St John of God Richmond Hospital Redevelopment SSD-10394

Response to Submissions Report

On behalf of
St John of God Health Care
June 2021

Figure 7 BAL Map (updated showing Wellness Centre 10m from boundary)

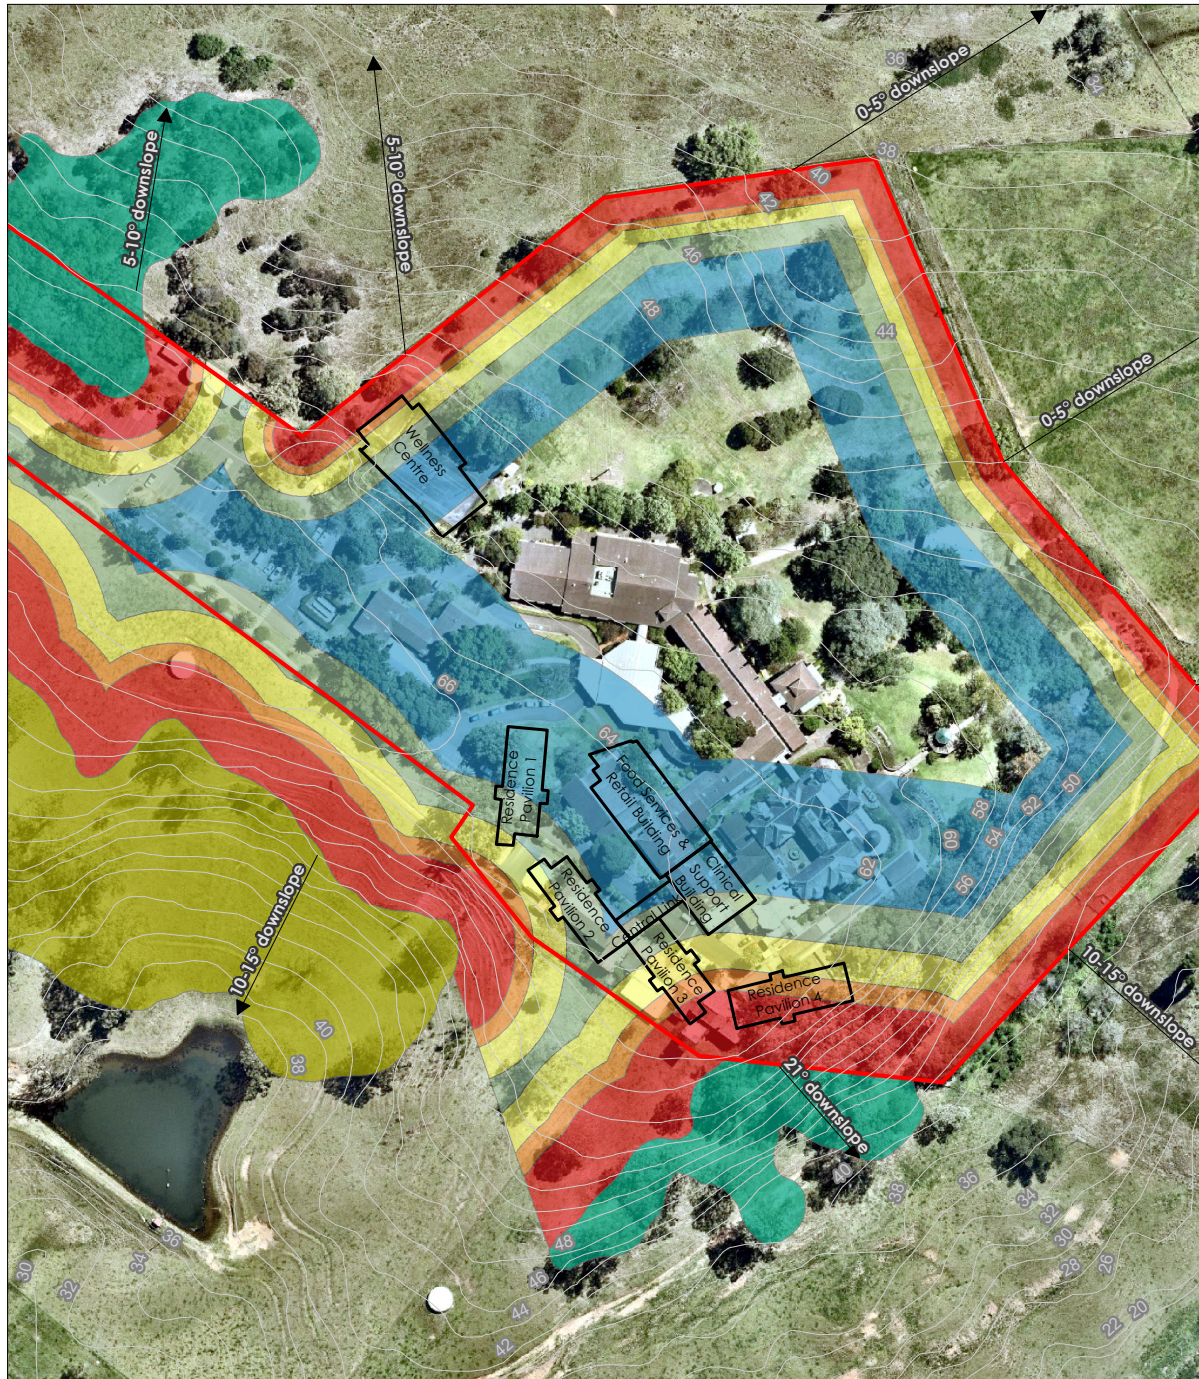
Issue	Response
Provide additional information to demonstrate that the proposed new buildings i.e. the Wellness Centre; Residence Pavilions and Garden Pavilions can achieve asset protection zone (APZ) requirement as per Table A1.12.1 of Planning for Bush Fire Protection 2019.	<p>The hospital is existing and the redeveloped Residence Pavilions and Garden Pavilions are infill Special Fire Protection Purpose (SFPP) development. As an existing SFPP development, the proposal is classified as infill SFPP development, and as such, Table A1.12.1 of PBP is not applicable.</p> <p>PBP states that the intention for any building work occurring within an existing SFPP development is to achieve a better bushfire outcome than if the development did not proceed. With this in mind, the construction of the redeveloped buildings will be undertaken in accordance with the Australian Standard for Construction of Buildings in Bushfire Prone Areas (AS3959).</p> <p>The applicant proposes to proceed with "Option 1" as discussed in section 9.6 of the original Bushfire Hazard Assessment at Appendix 7 of the EIS, which requires no easement on the adjoining property. This has been clarified in the updated bushfire report.</p> <p>Also, as noted above, it has been clarified that a radiant heat exposure of 10kW/m² will not be experienced by occupants of the Wellness Centre as the building will be closed and not occupied in the event of grass fire. This will be enforced via the Emergency Management and Evacuation Plan.</p> <p>Overall, the proposed buildings meet the requirements of PBP with no off-site APZ requirement.</p>

- The Wellness Centre has been further set back from the boundary (6m to 10m) to get the building out of the flame zone. Due to site constraints, the building cannot be moved to another location.
- As requested by RFS, a performance-based assessment for the Wellness Centre has been carried out (see calculations at Attachment 5 of the updated bushfire report).
- It has been clarified that a radiant heat exposure of 10kW/m² will not be experienced by occupants as the building will be closed and not occupied in the event of grass fire. This will be enforced via the Emergency Management and Evacuation Plan.
